## Kelsale-cum-Carlton Parish Council Review of the SZC Co. Public Consultation (3rd to 27 August 2021)

## CHAPTER 2. TEMPORARY DESALINATION PLANT (PROPOSED CHANGE 19)

### 2.3. Description of Proposed Change 19

Plate 1.1: Indicative potable and non-potable water demand throughout the construction period

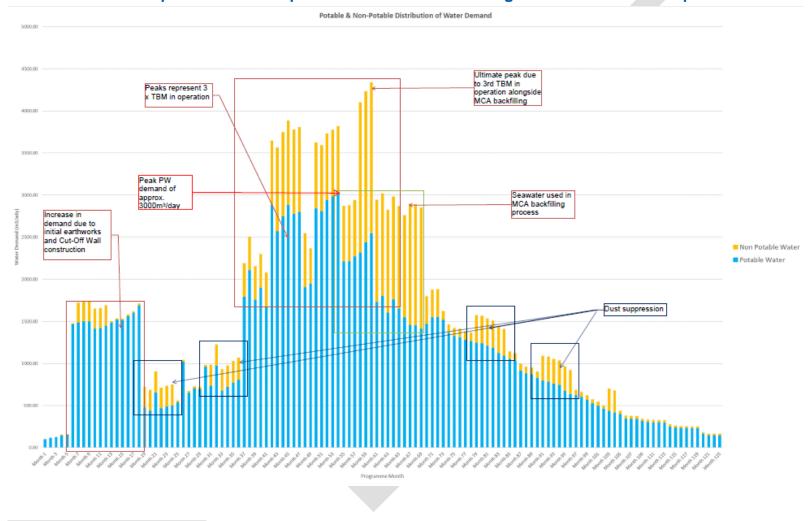
It is of concern that as of 23<sup>rd</sup> July 2021 it is stated by Walker Morris LLP on behalf of Northumbrian Water Limited (NWL) that *“the information provided to NWL by the Applicant regarding the peak water supply requirements for Sizewell C has recently been updated and materially increased and is still not fixed”*, Particularly as the document (referred to above) stated the water figures included in January were supposed to be upper requirements.

It is unclear apart from the Main Development Site, how the other proposed developments would be supplied with water. Would this be bought in from the Main Site desalination plant (should it be accepted) or/and tankers? Alternatively, would this further exacerbate an already over abstracted water supply? A water supply which coincidentally, MPs warned on 10<sup>th</sup> July 2020; “Some parts of England are at serious risk of running out of water within the next 20 years ...”.
